Our Ref: 24/00172/HFUL
Your Ref: Cockram Garage

**South Cambridgeshire District Council
Application for Planning Permission**

Proposal: Extension of annexe to join house and create a front porch to the house

Site address: 4A Willingham Road Over Cambridgeshire CB24 5PD

PROPOSED PLANS & ELEVATIONS

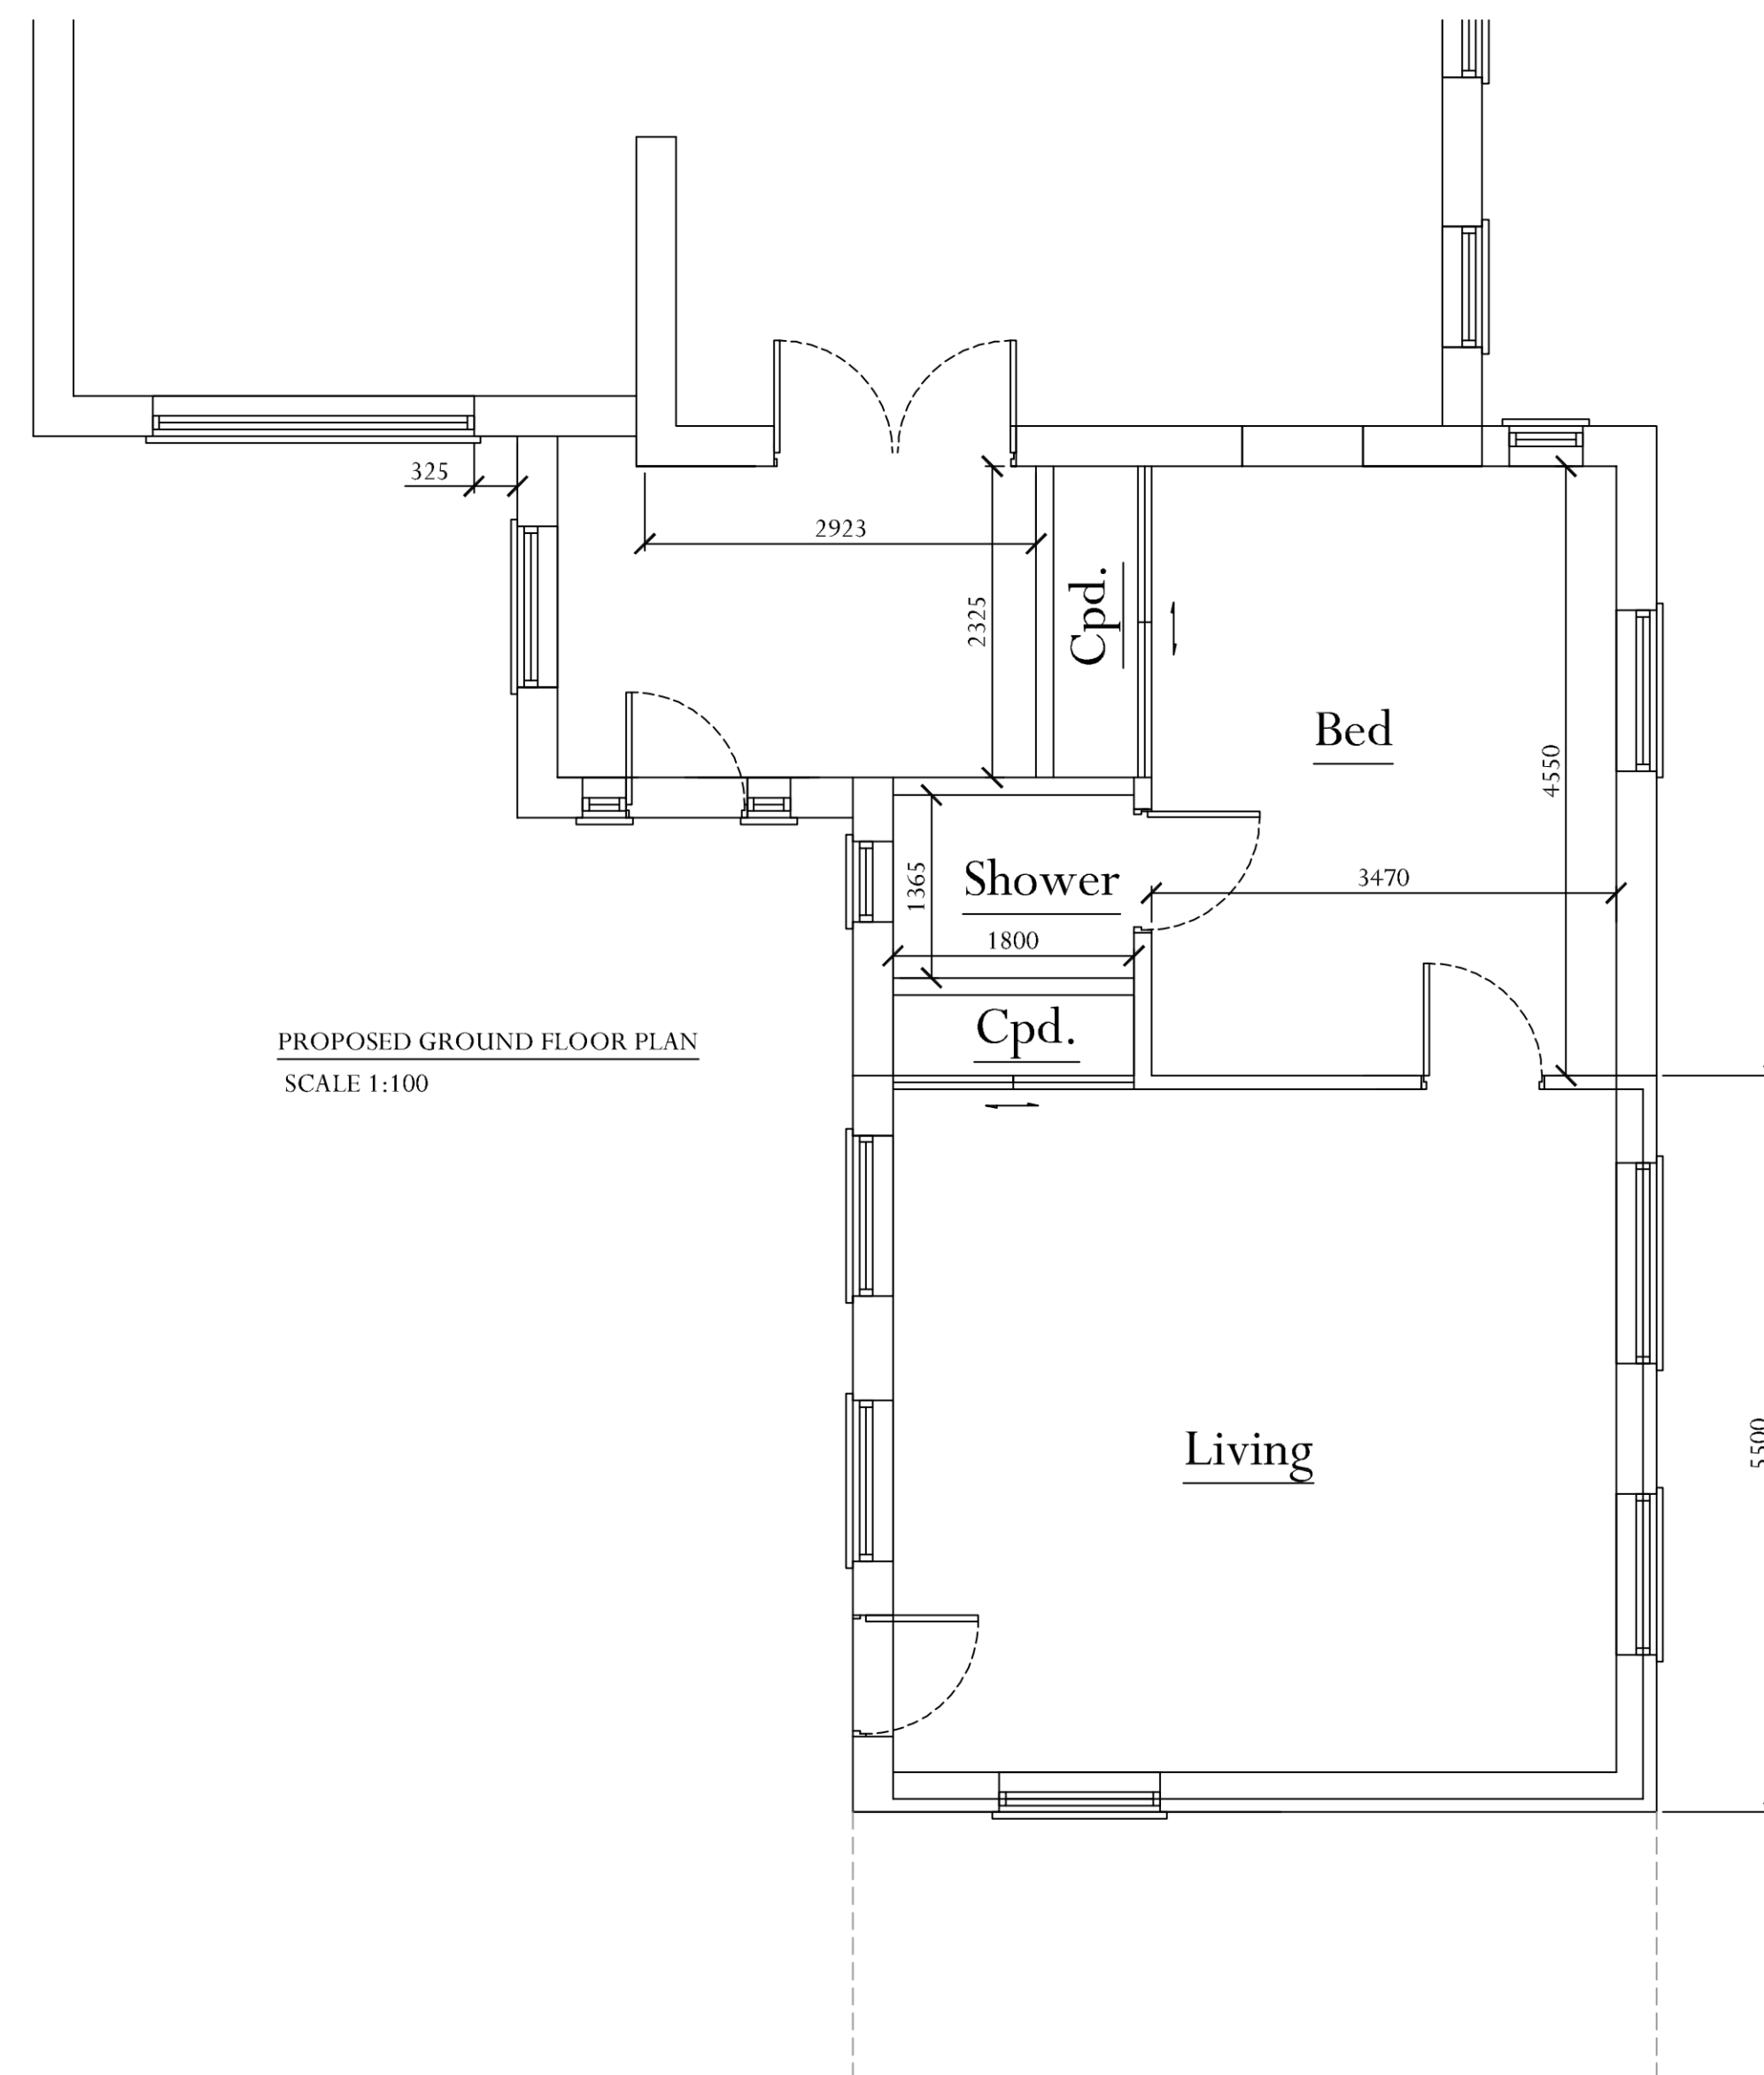
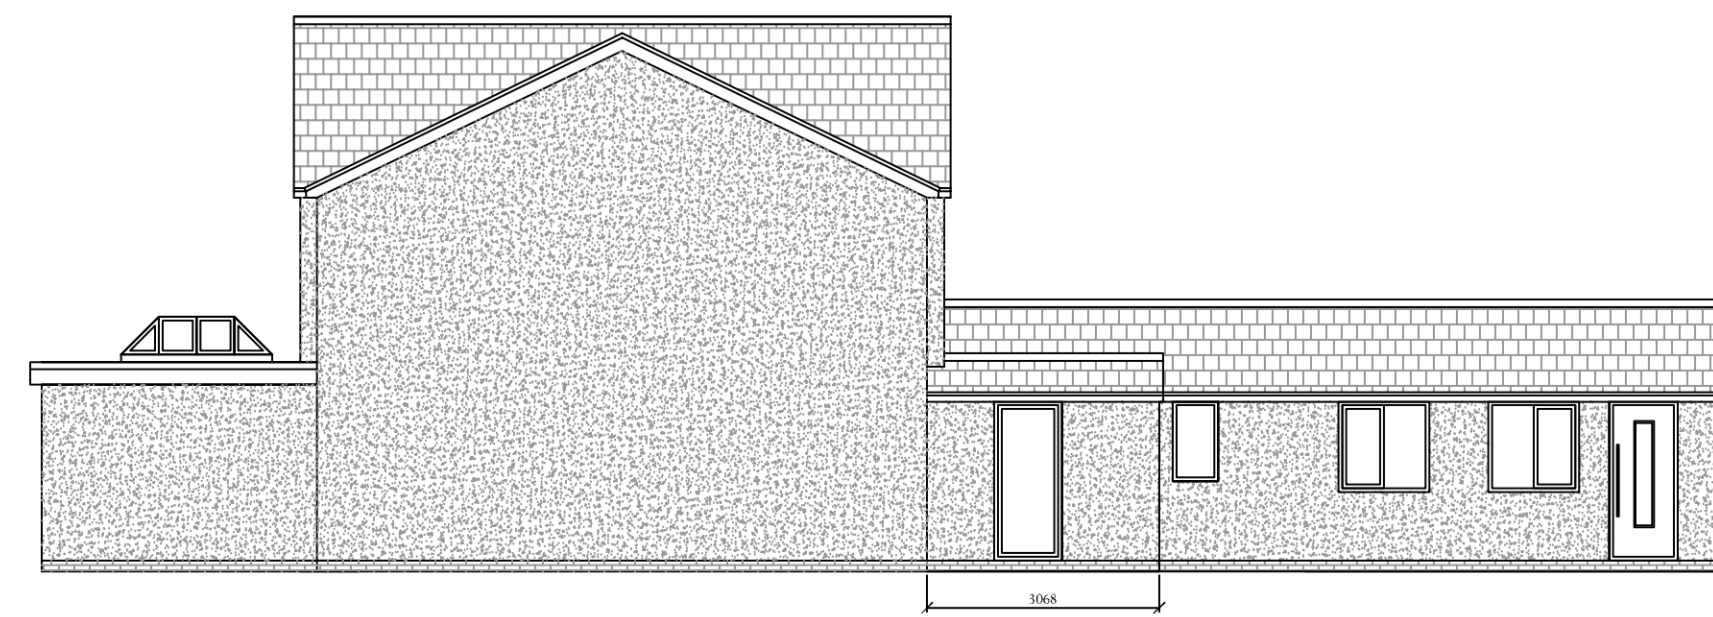
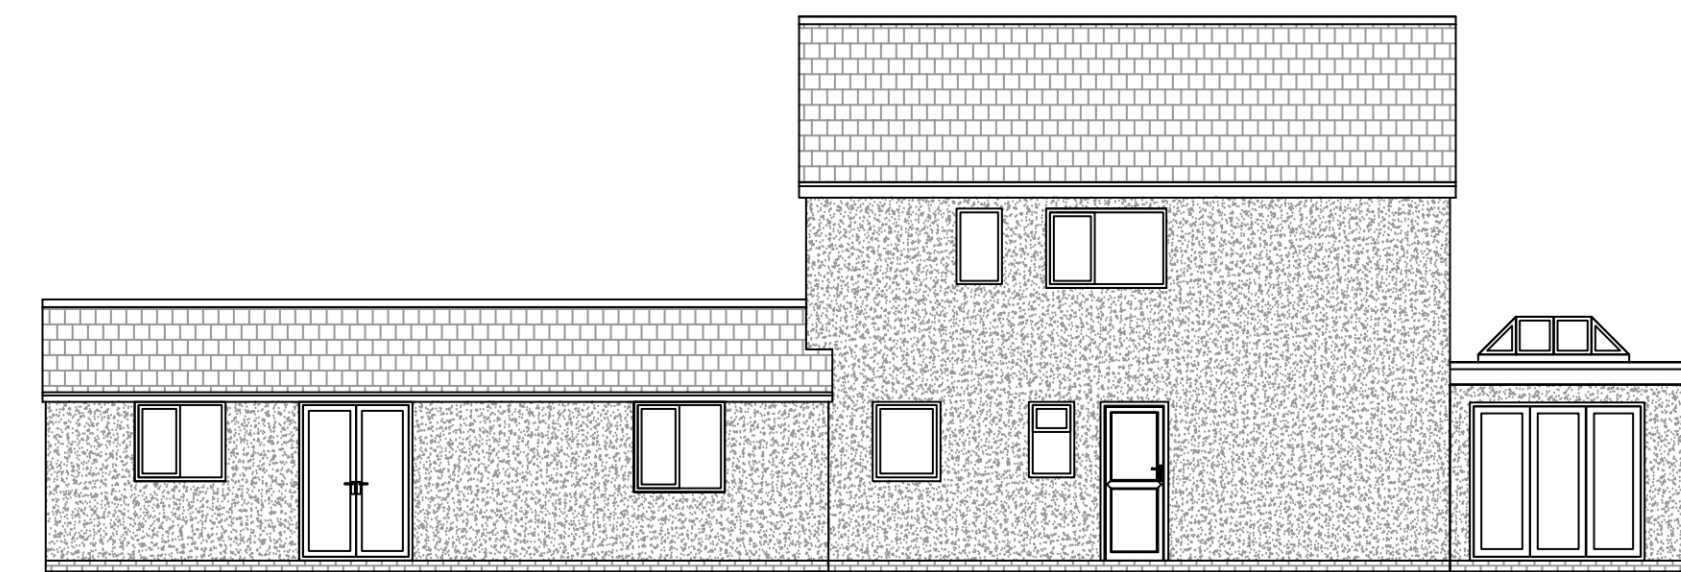
1. The proposal description status you are proposing link/extension between main house and the annexe, changes to the annexe roof and the front porch to the main house.

Looking at the drawings it seems there a garage conversion to an annexe? Do we need to add the garage conversion to an annexe to this application.

Please clarify the above.
